Project Memo

DATE: September 23, 2025
TO: Community Design Solutions, LLC & J&M Discount Towing LLC
FROM: Dustin Kiska, Planner (505)-924-3366 & Daniel Soriano, Planner (505) 924-3935
City of Albuquerque Planning Department
RE: Project # SP-2025-00066 Site Plan – EPC

A3.1

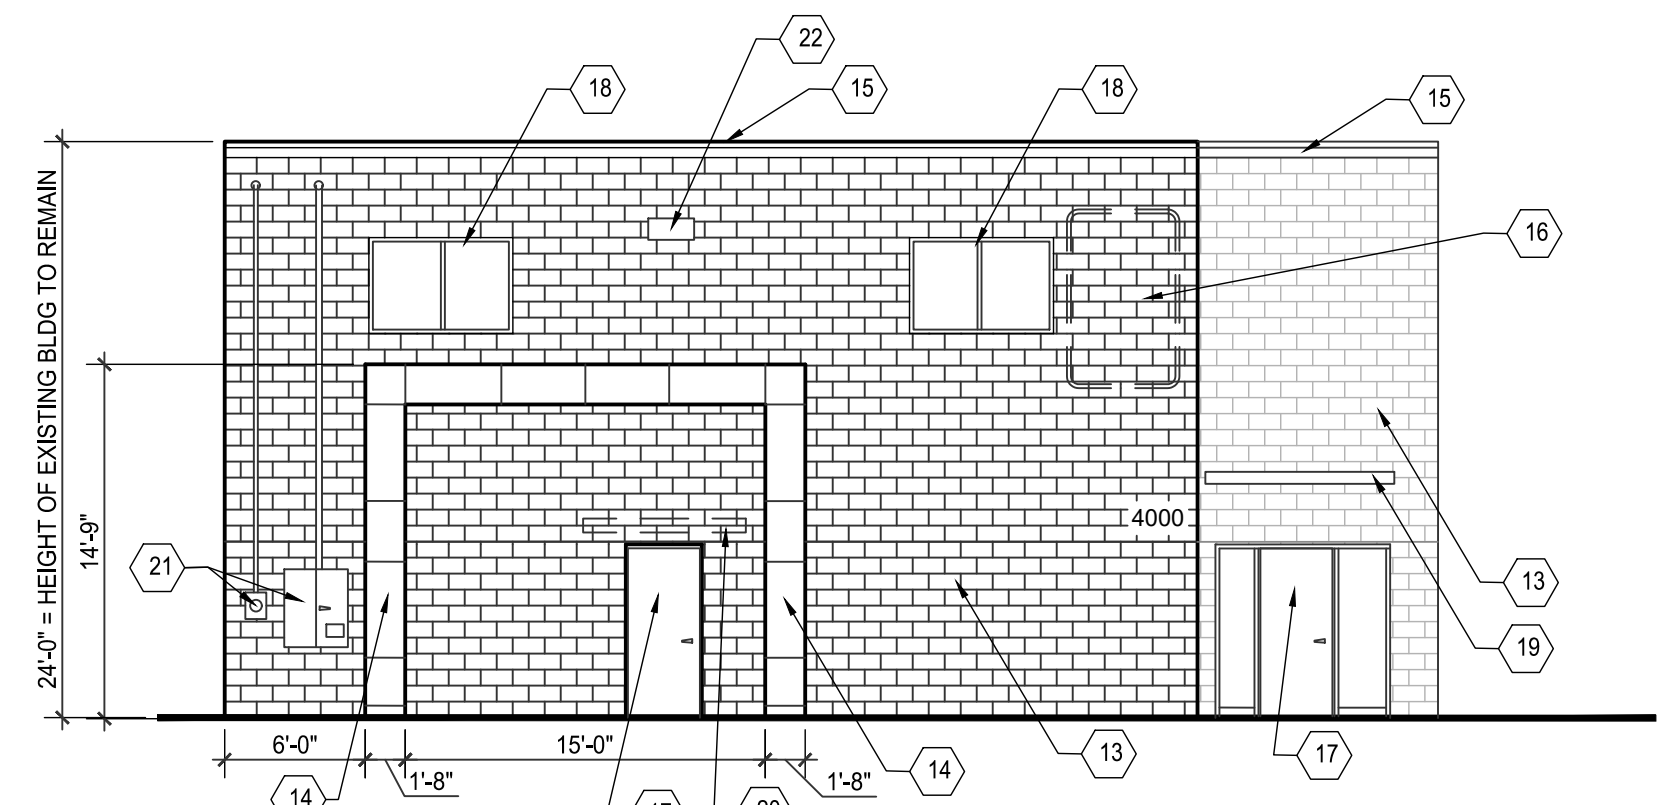
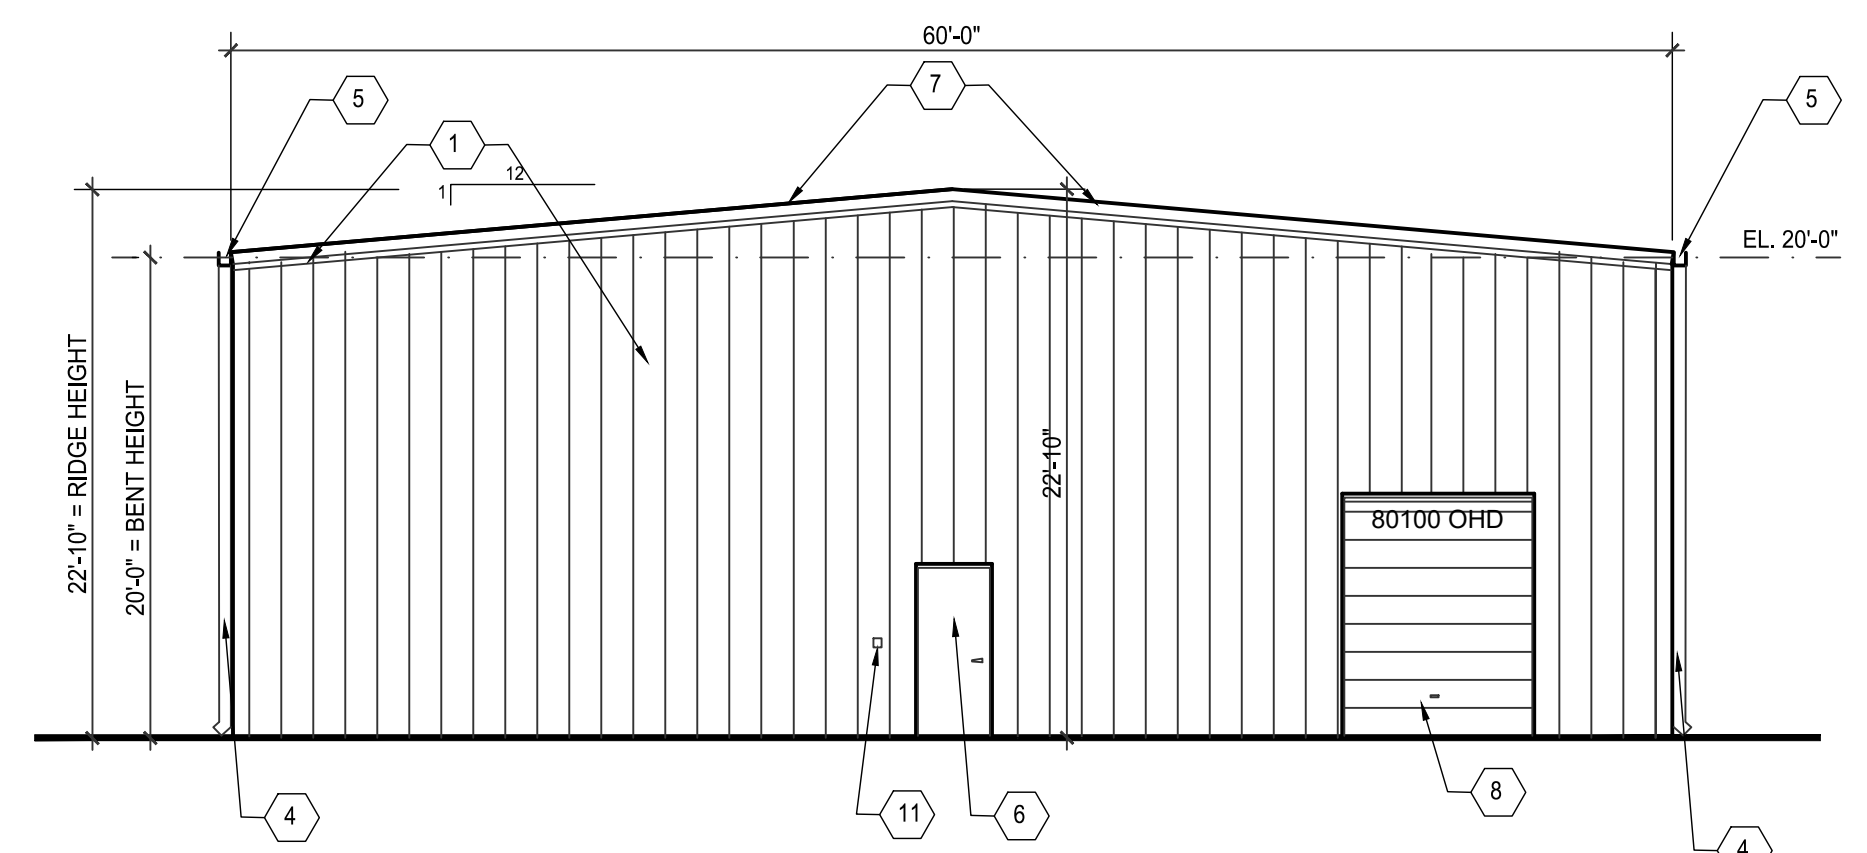
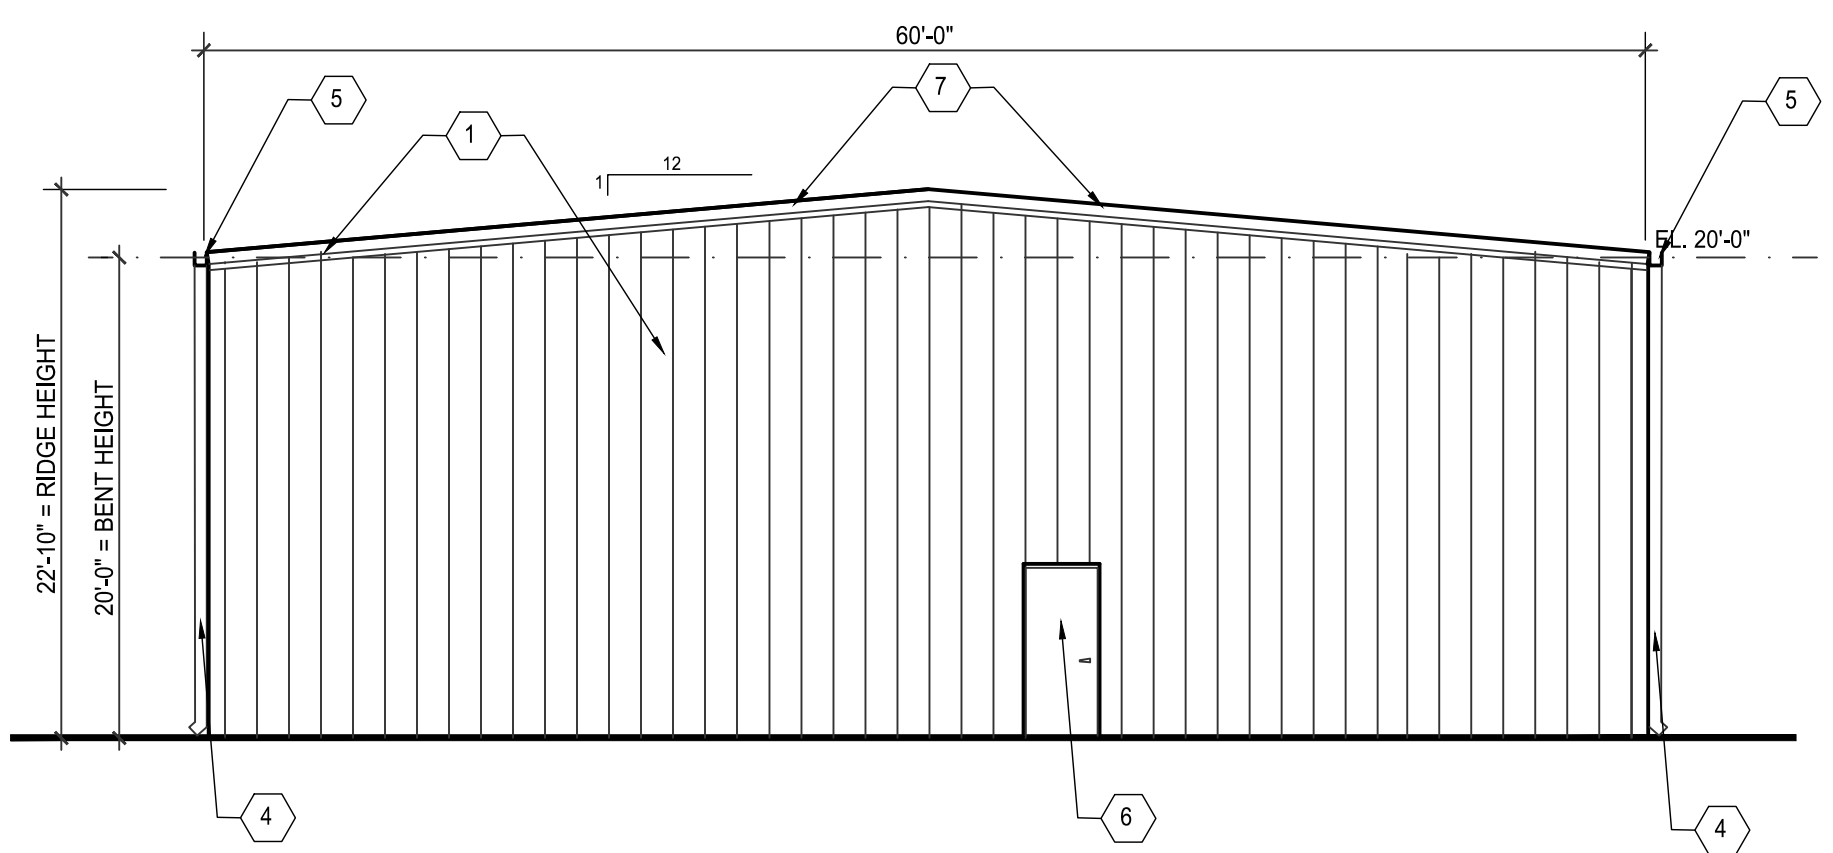
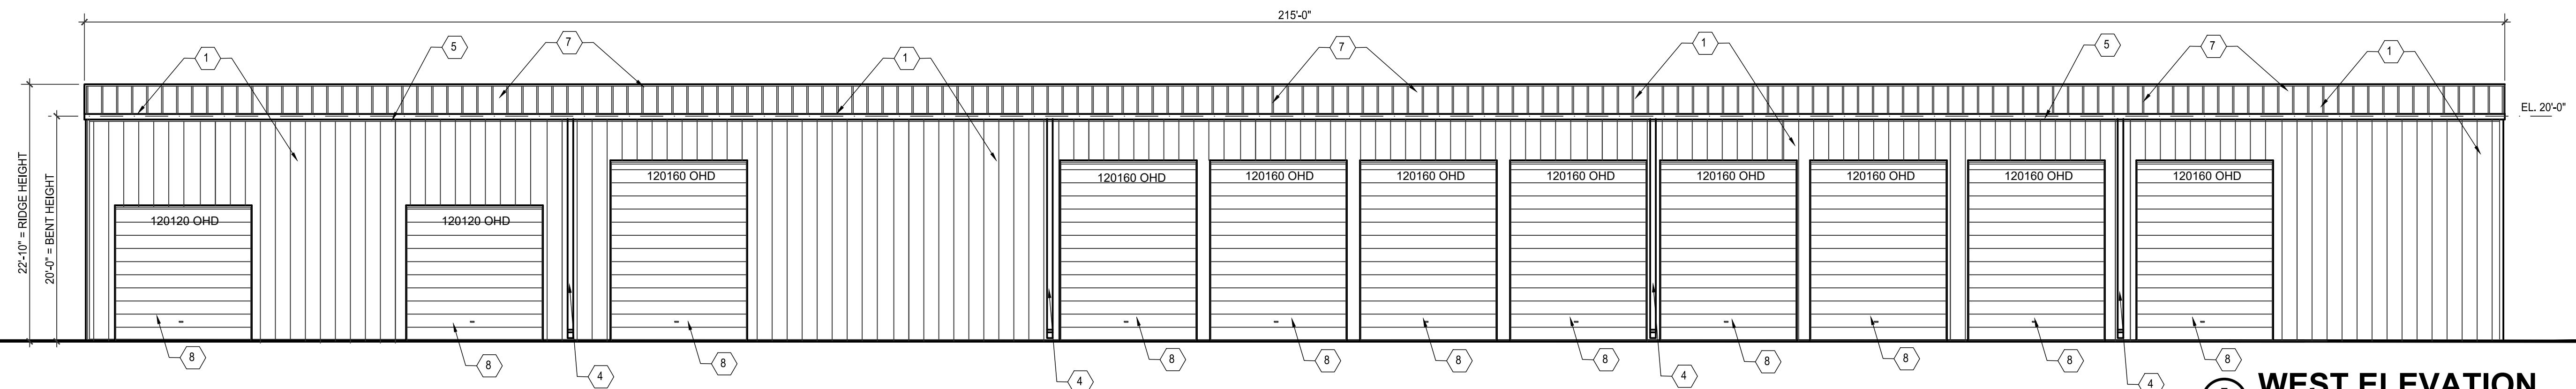
- Please add an additional elevation sheet of the existing building elevations, showing north, east, west, south elevations, with keyed notes.
- Please provide HVAC unit location on the Elevation plan.

DISCOUNT TOWING HEADINGLY AVE.	DRAWN BY DEM
	GRADING AND DRAINAGE PLAN	DATE 10-10-22
	SHEET # C1	DISCOUNT TOWING DWG
DAVID SOULE P.E. #14522	RIO BOX 53204 ALBUQUERQUE, NM 87199 (505) 321-8099	JOB #

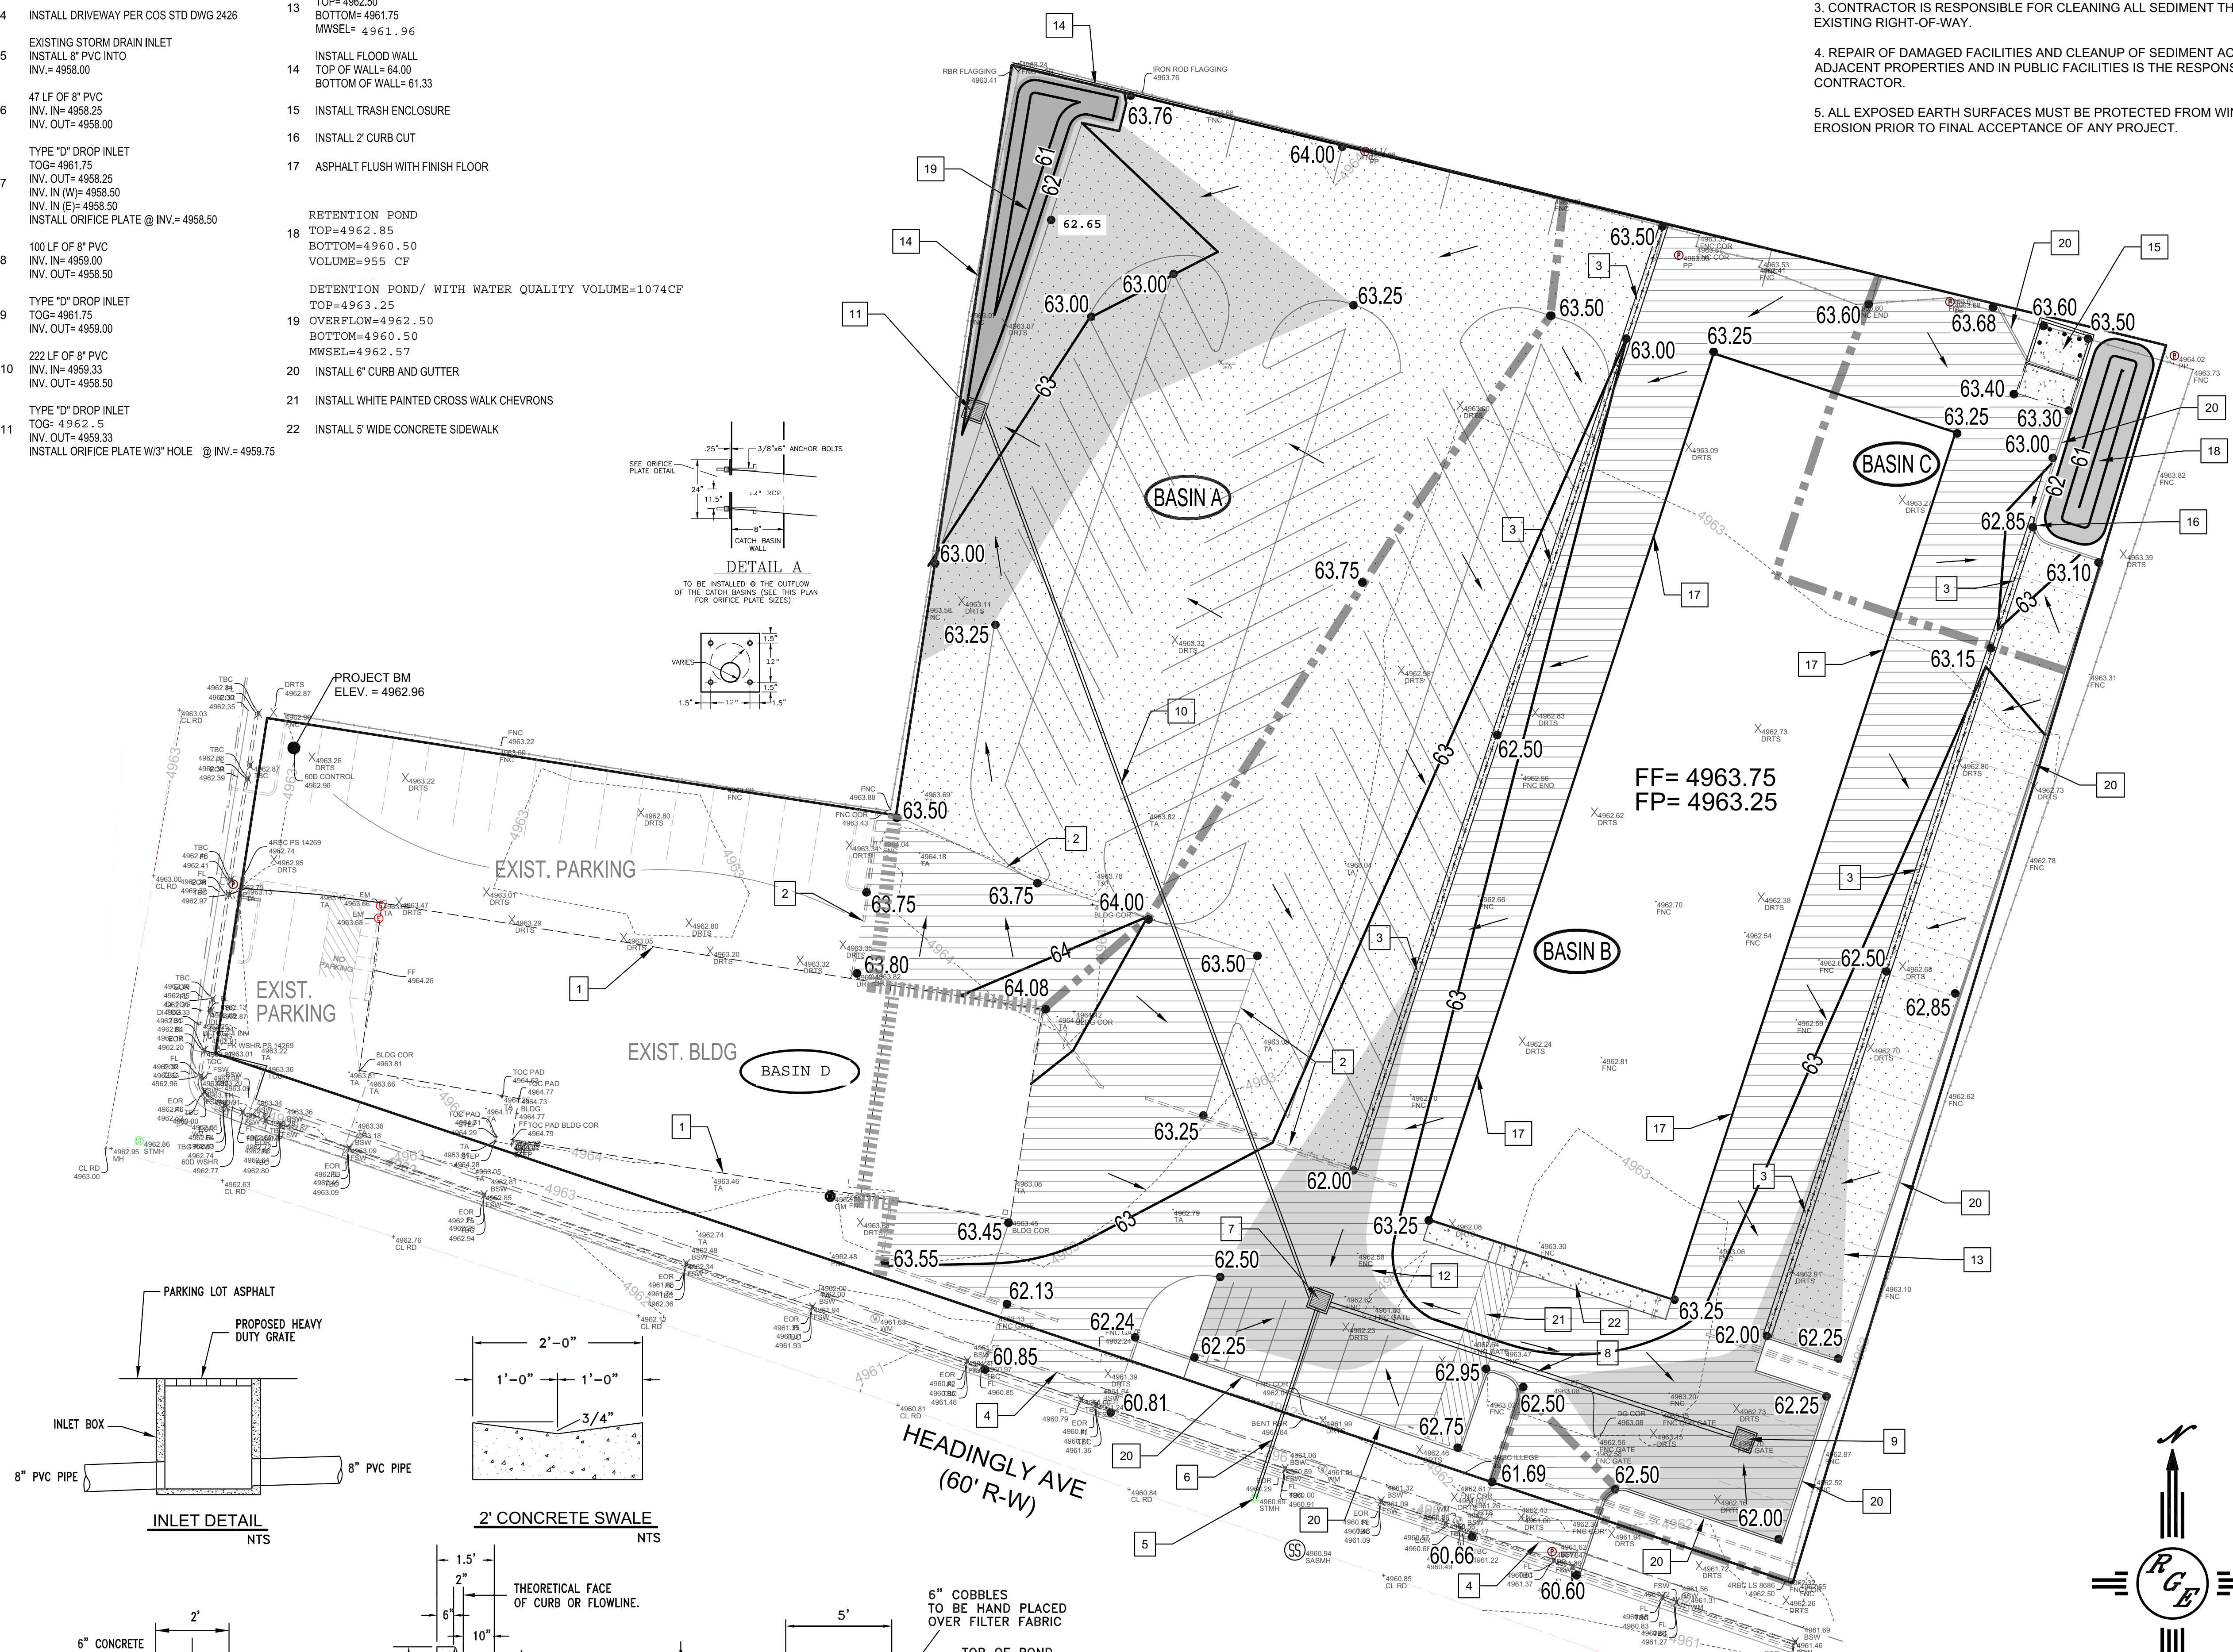
- Please provide detail of flood wall, Grading and drainage sheet keyed note (14).

- Please provide section details of Retention and Detention ponds, Grading and drainage sheet keyed note (18) & (19)

- See detail revisions above
